Current Zoning: IC-1 (institutional campus) and R-12MF(CD) (multi-family residential, conditional)
Proposed Zoning: R-12MF(CD) (multi-family residential, conditional) and R-12MF(CD) SPA (multi-family residential, conditional, site plan amendment)

Approximately 3.9 acres located on the north side of Albemarle Road, west of Harrisburg Road, and south of Pence Road.

The petition proposes to allow up to 47 single family attached residential (townhome) units on a vacant parcel located north of Albemarle Road and west of Circumferential Road.

PLANNING STAFF REVIEW

<p>Issue Date: 12-21-22</p>	No.	Date	Description	1	7/14/23		2	5-25-23		3	3-10-23		4	1-10-23		<p>Sheet 1 of 1</p>	<p>Project Number: 199.005</p>
No.	Date	Description																
1	7/14/23																	
2	5-25-23																	
3	3-10-23																	
4	1-10-23

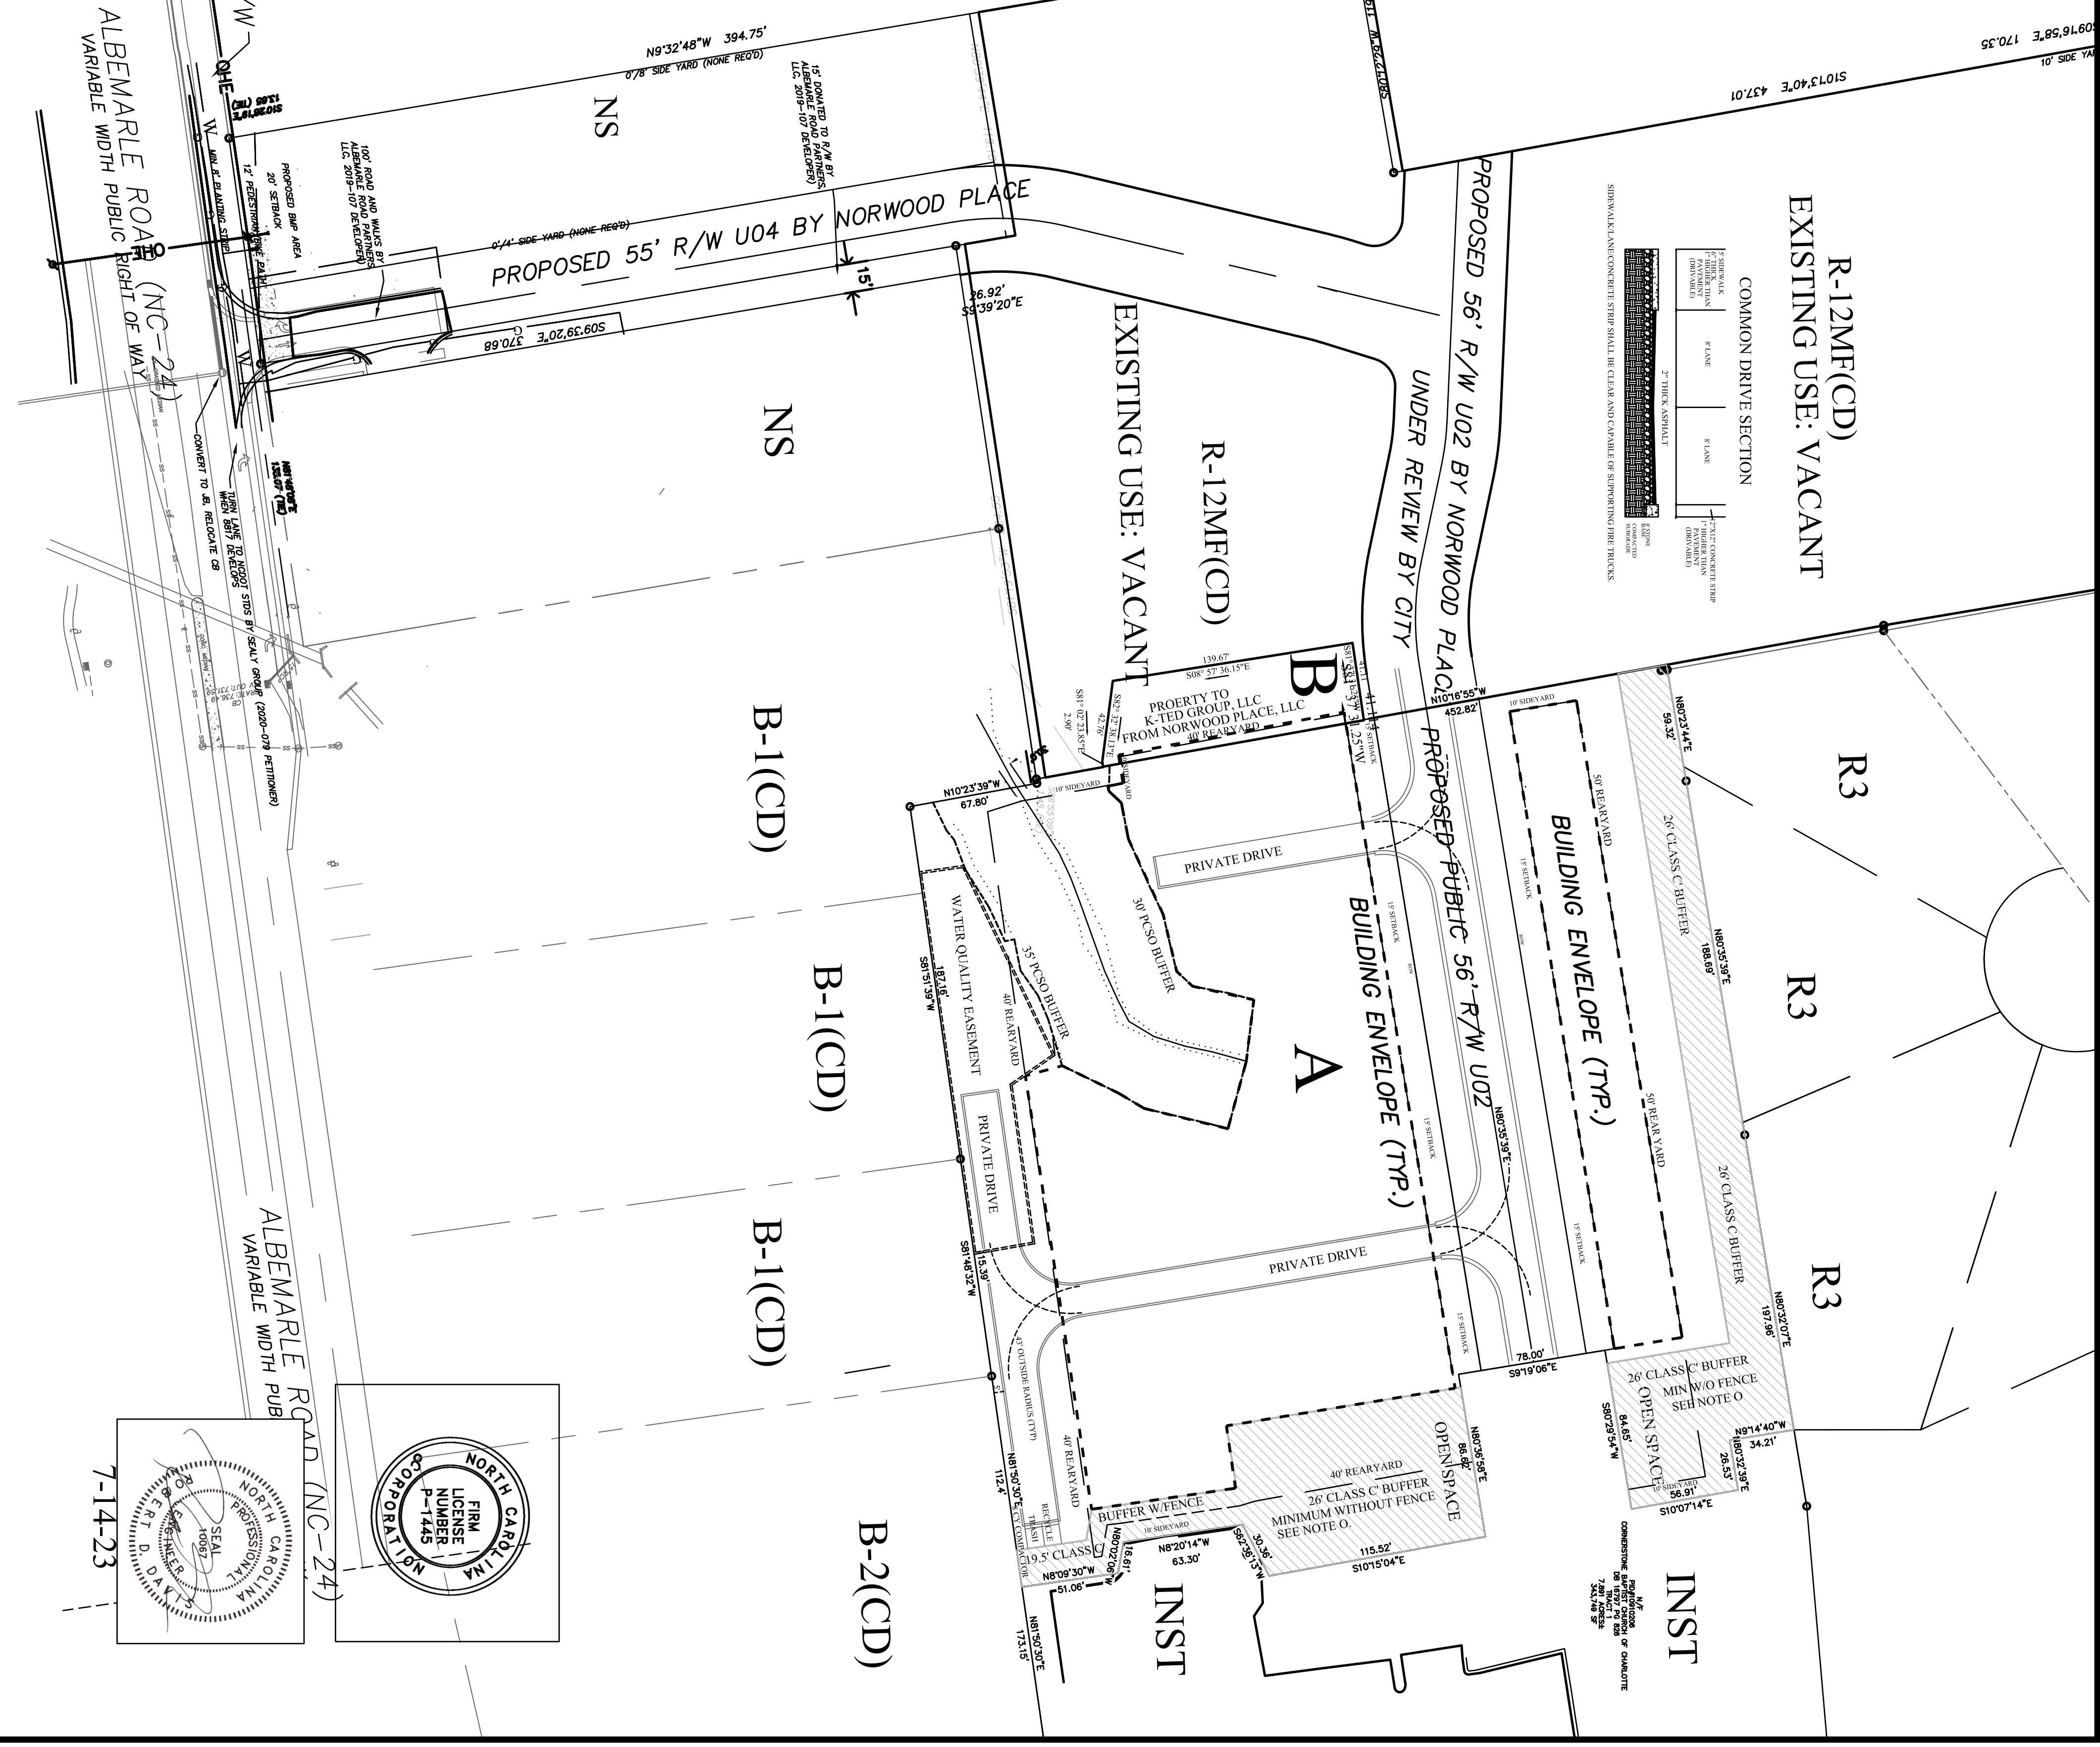
5. Site must show a minimum of 15% of the overall site as tree save. This requirement must be shown on the site plan.
6. ~~**New Outstanding Comment resulting from most recent site plan:** Remove notes under Environmental Features as marked up. Please include notes from previous versions of the rezoning plan (see ACCELA):~~
